Our Ref: PC10001

16th December, 2014.

I refer to North-South Electricity Interconnector Project and to the draft application file submitted to An Bord Pleanála (Competent Authority) under the PCI Process on 7th November, 2014.

An Bord Pleanála in its role as competent authority under PCI has examined the draft application file under Article 10.4(c) of Regulation 347/2013 and lists hereunder missing information (addressing subjects identified under Article 10.4(a)) which is requested to be submitted.

Figure 13.1: Indicative Corridors of the Proposed Leinster Orbital Route

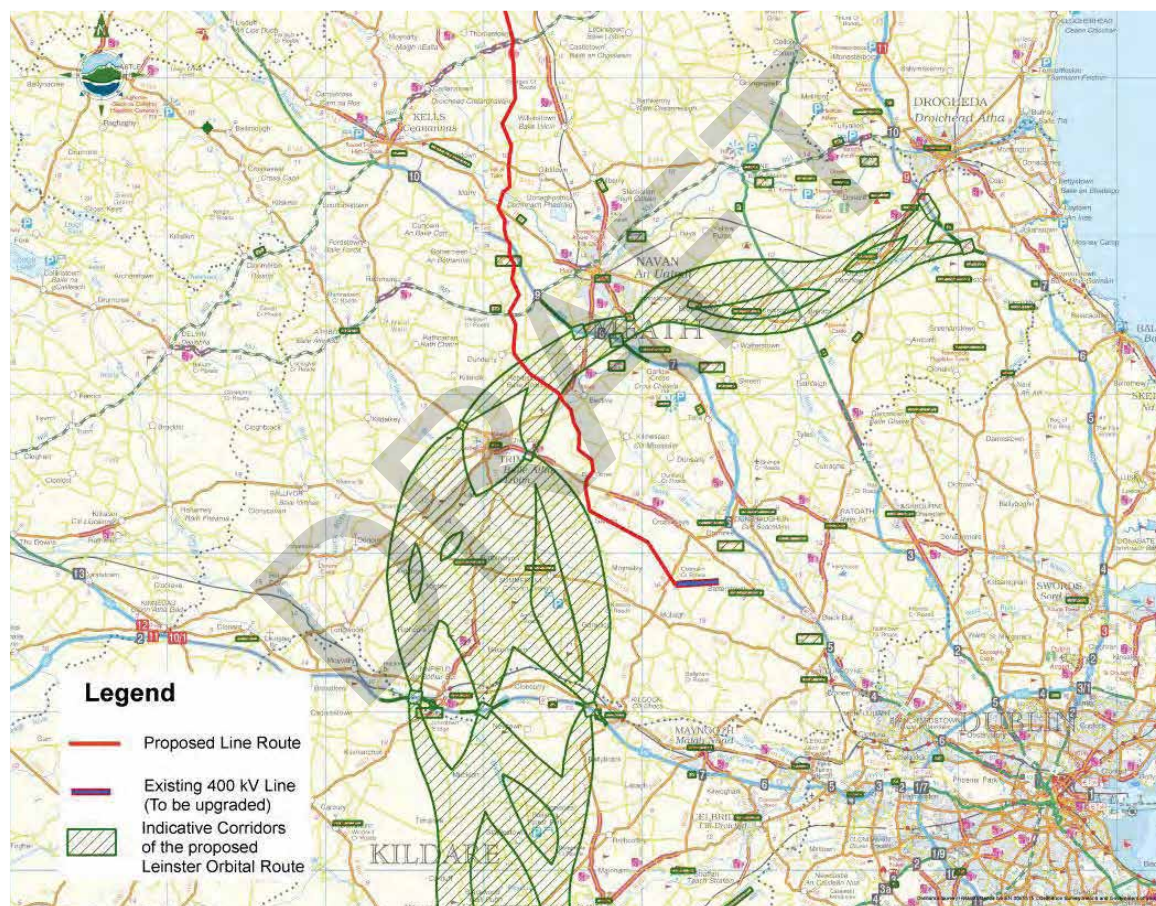
The indicative route of the proposed Leinster Orbital Route and relationship with the proposed development should be identified, based on best available information.
